Great North Road Solar and Biodiversity Park

Draft Statement of Common Ground with Nottinghamshire County Council

Document reference – EN010162/APP/8.4A1B

~~January~~February 2026

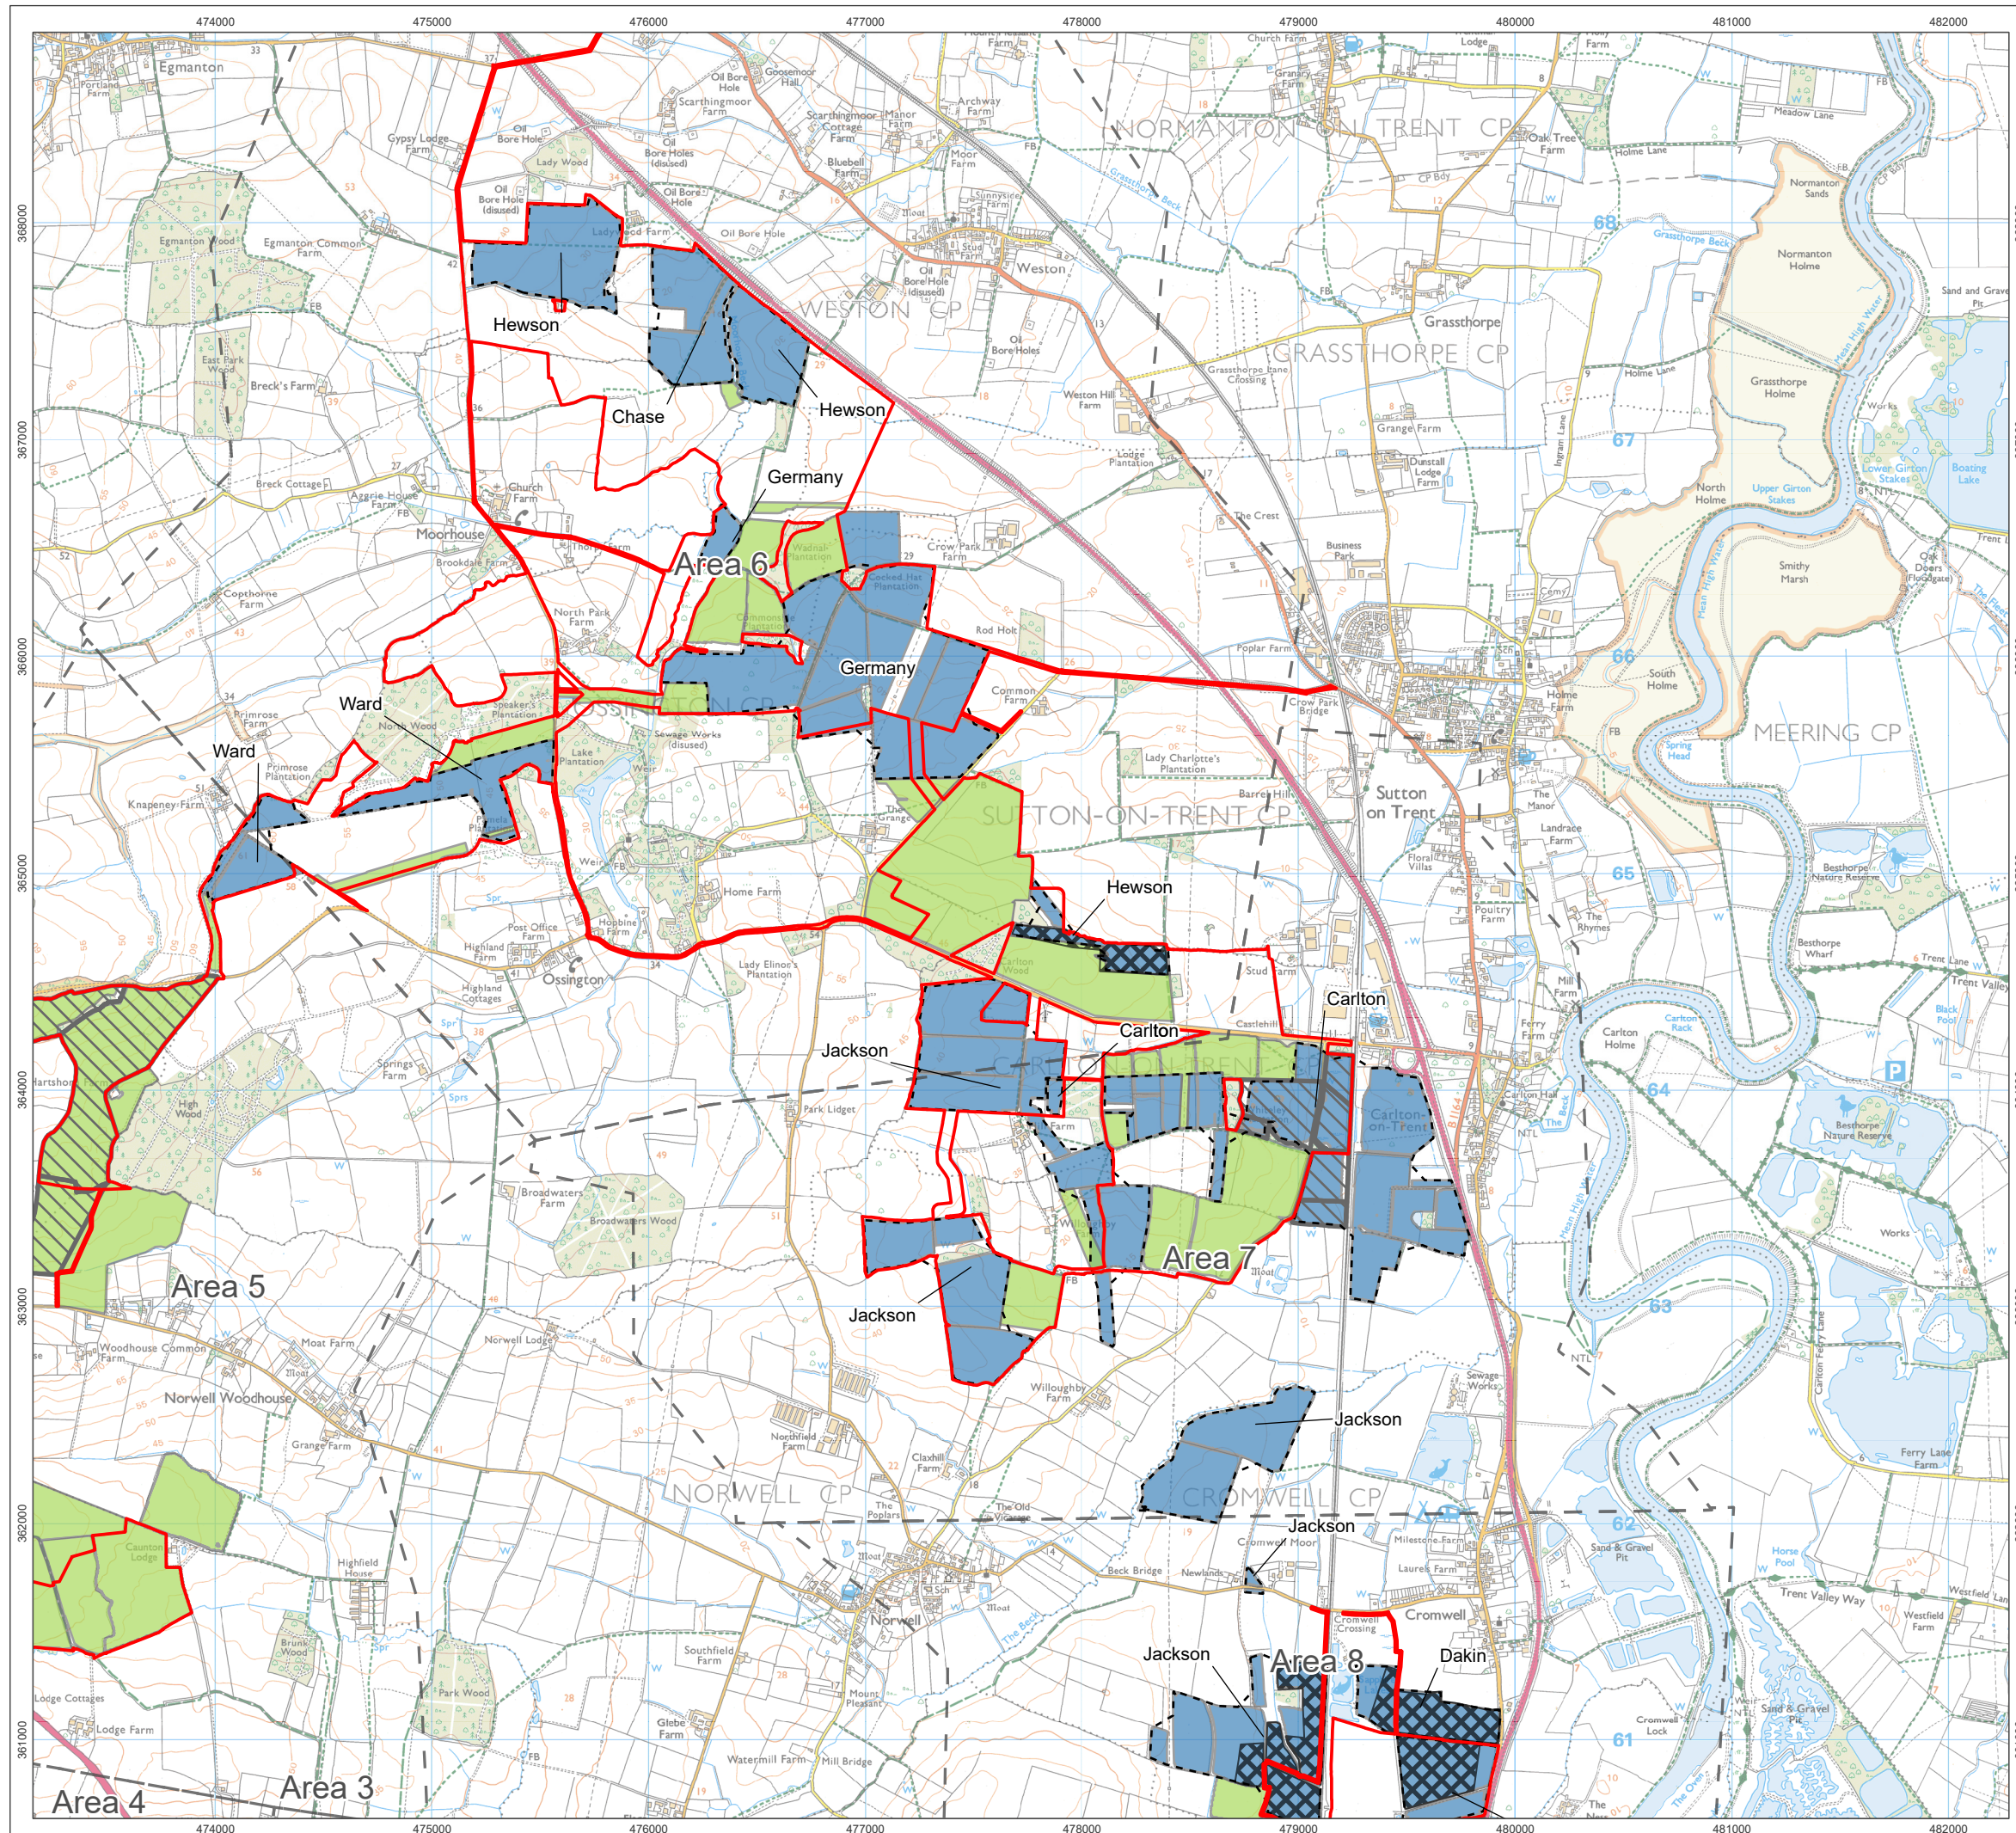
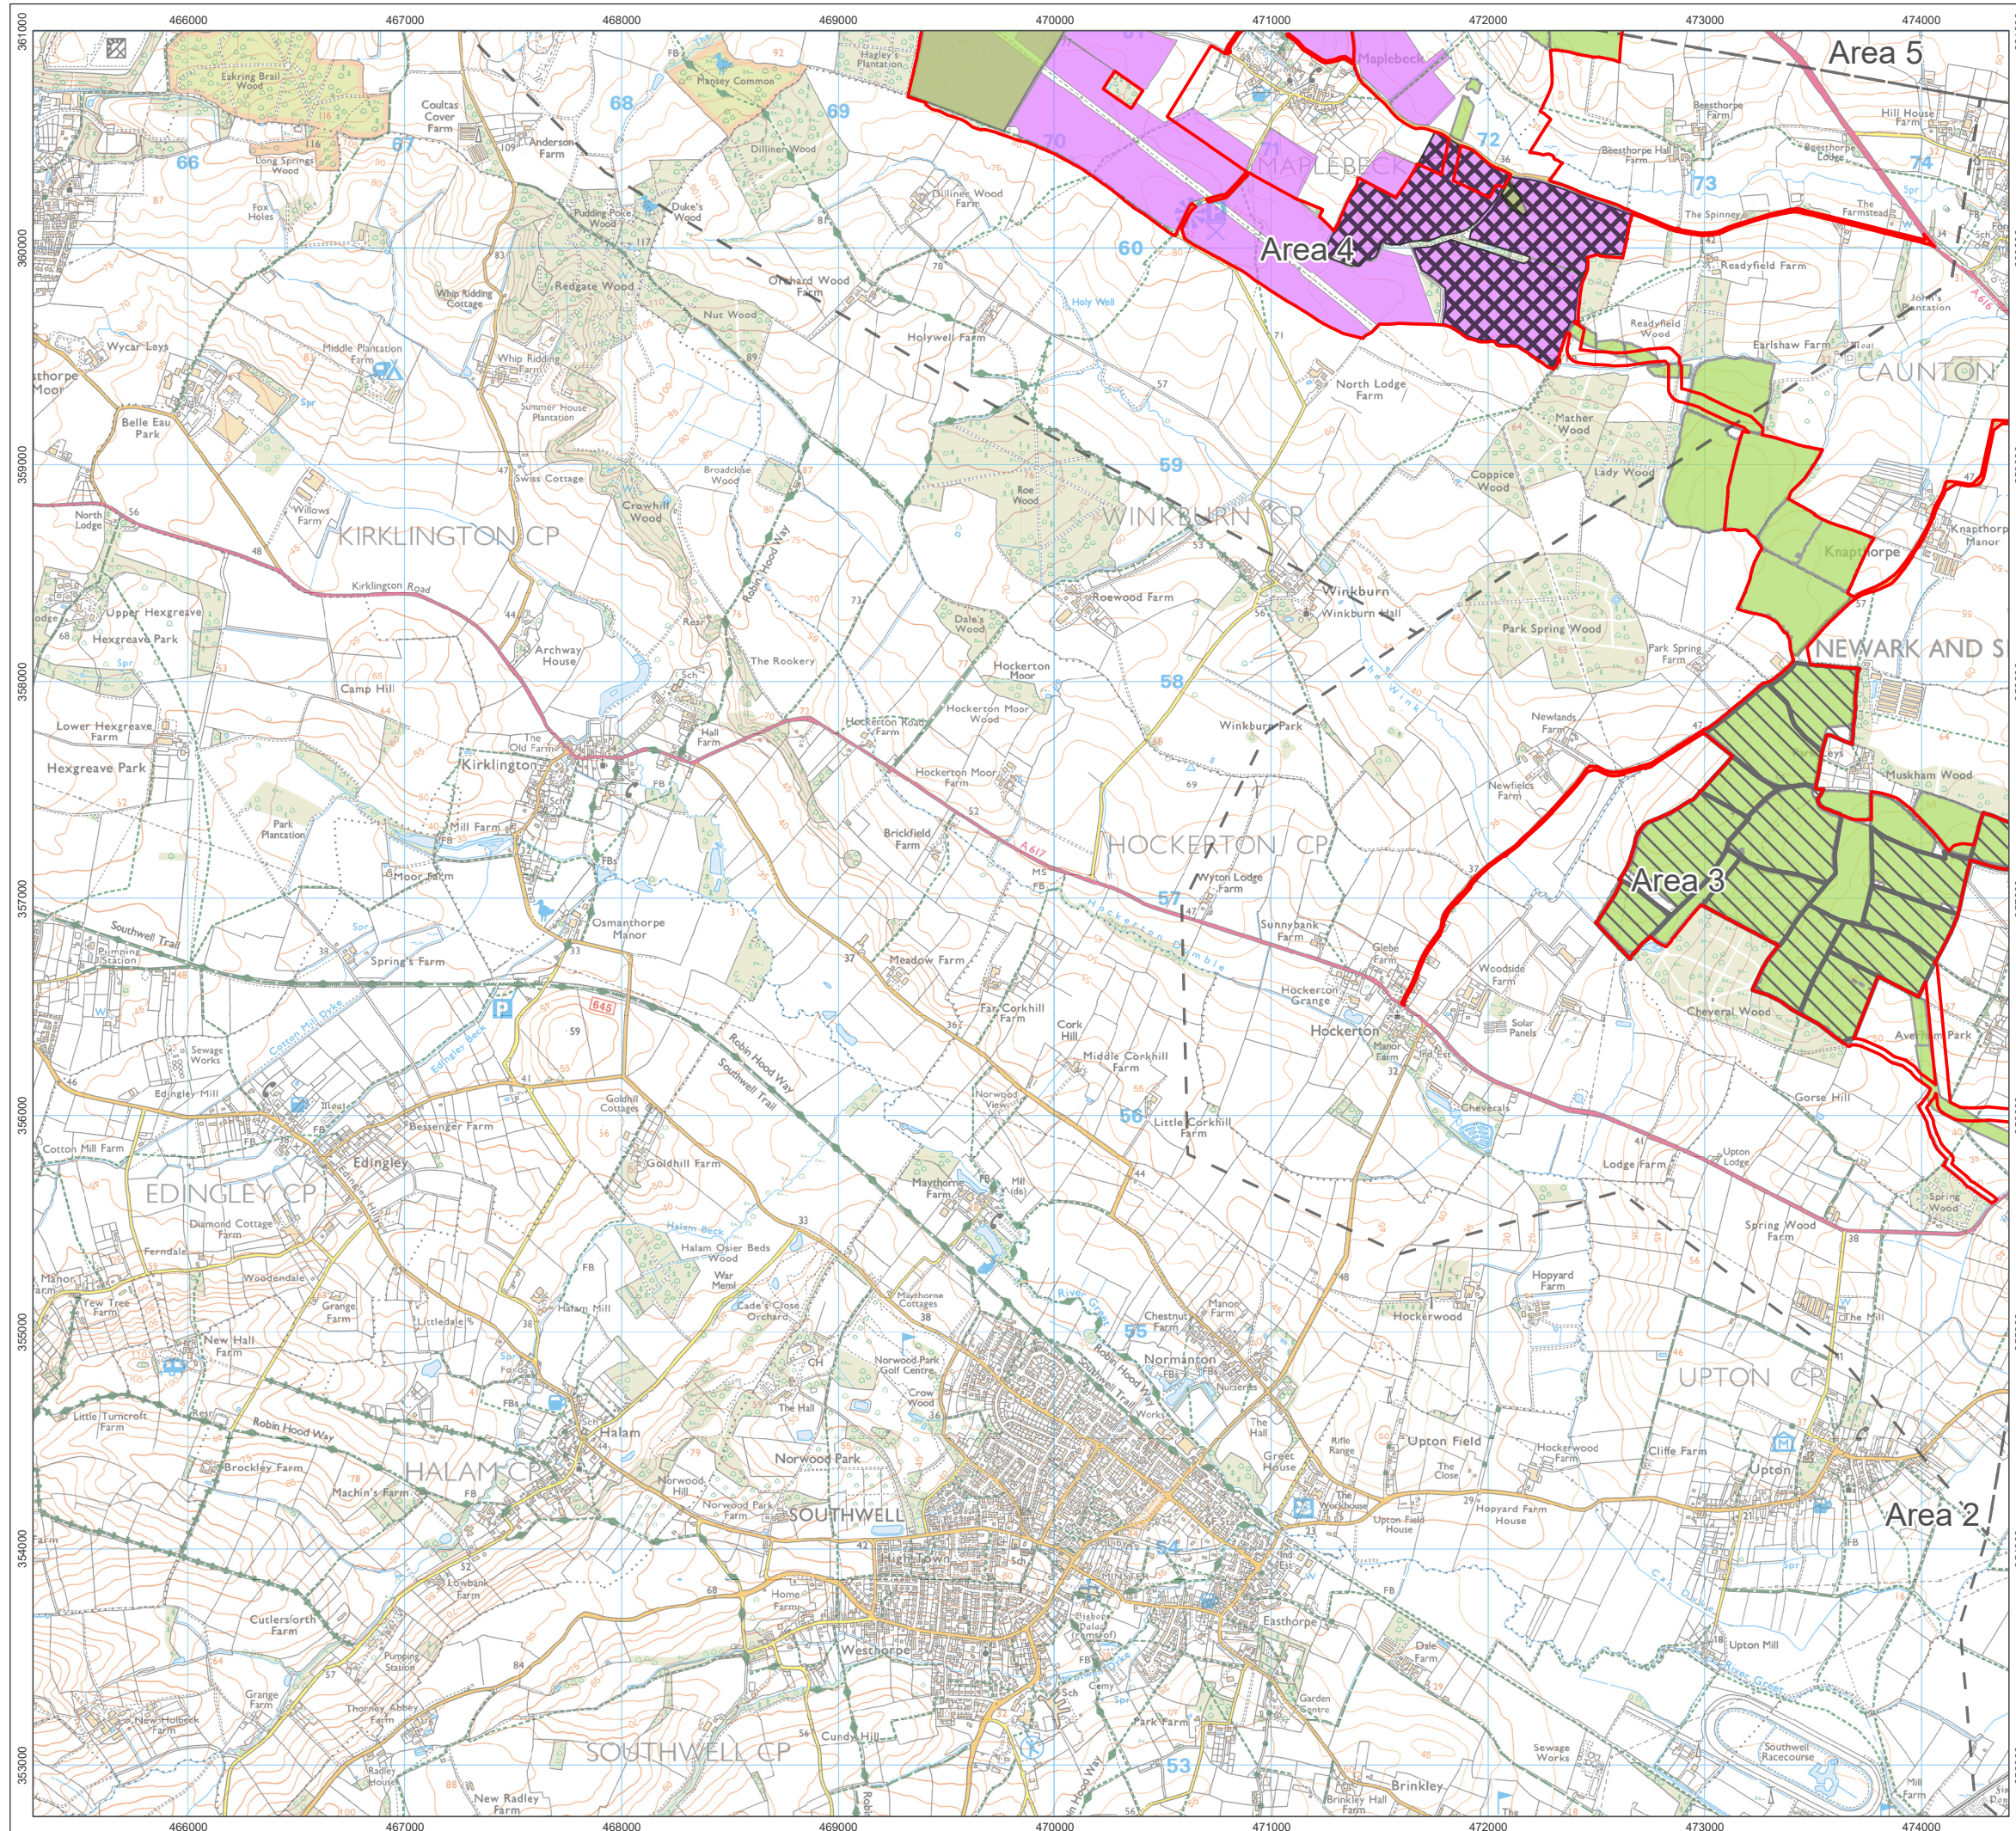
Ref	Relevant Documents	Description of Matter	Applicant's <u>NCC's</u> Position	<u>NCC's</u> Applicant's Position	Status
			<p>data to inform the <u>ES is welcomed.</u></p> <p><u>In regard to the completeness of survey to date it should be noted that geophysical baseline survey coverage was c.90% and that trenching tested all geologies. This is considered to be proportionate, in line with developing best practice guidelines and sufficient to inform the ES for the Environmental Statement (ES) and an initial phase(s) of trial trench evaluation.</u></p> <p><u>The scope of post-consent investigation. However, the applicant acknowledges that the geophysics results have not been tested in their entirety (Para. 48) which we consider a serious limitation when undertaking an appropriate assessment and gathering sufficient data to inform significance and impact.</u></p> <p><u>However, the OAMS has made provision for which is set out in the OAMS, will post consent geophysics and trial trench evaluation work that will</u></p>	<p>the majority of the order limits. This to date has been largely sufficient to provide an acceptable level of data to inform the <u>ES is welcomed.</u></p> <p><u>In regard to the completeness of survey to date it should be noted that geophysical baseline for the Environmental Statement (ES) and an initial phase(s) of trial trench evaluation survey coverage was c.90% and that trenching tested all geologies. This is considered to be proportionate, in line with developing best practice guidelines and sufficient to inform the ES.</u></p> <p>However, the applicant acknowledges that the geophysics results have not been tested in their entirety (Para. 48) which we consider a serious limitation when undertaking an appropriate assessment and gathering sufficient data to inform significance and impact.</p> <p>However, the OAMS has made<u>The scope of post-consent investigation, provision for post</u></p>

Ref	Relevant Documents	Description of Matter	<u>Applicant's</u> <u>NCC's</u> Position	<u>NCC's</u> <u>Applicant's</u> Position	Status
			<p><u>characterise the archaeology and assess impact.</u></p> <p>It is expected that the post-consent investigation and subsequent mitigation will be developed in line with emerging best practice as set out in Archaeology and Solar Farms: Good Practice Guide: A toolkit for developers, archaeological advisers, consultants and contractors.</p> <p>ES Volume 4, Appendix A11.8: Outline Archaeological Mitigation Strategy (AMS) [EN010162/APP/6.4.11.8A] has been updated at Deadline 2 to address the matters highlighted by NCC in respect of the programme of works and</p> <p><u>During the examination period, we would expect to further refine the OAMS in consultation with the applicant and their consultants and agree an outline programme for the post-consent completion of the assessment work. There will also need to be specific wording included in the DCO with respect</u></p>	<p>behind, and details on this will help influence the level of intrusive evaluation required to characterise the archaeology and assess impact.</p> <p>During the examination period, we would expect to further refine the OAMS in consultation with the applicant and their consultants and agree an outline programme for the post-consent completion of the assessment work. There will also need to be specific wording included in the DCO with respect to the archaeology requirement which secures</p> <p><u>It is expected that the post-consent investigation and subsequent mitigation will be developed in line with emerging best practice as set out in Archaeology and Solar Farms: Good Practice Guide: A toolkit for developers, archaeological advisers, consultants and contractors.</u></p> <p><u>ES Volume 4, Appendix A11.8: Outline Archaeological Mitigation Strategy (AMS) [EN010162/APP/6.4.11.8A] has</u></p>
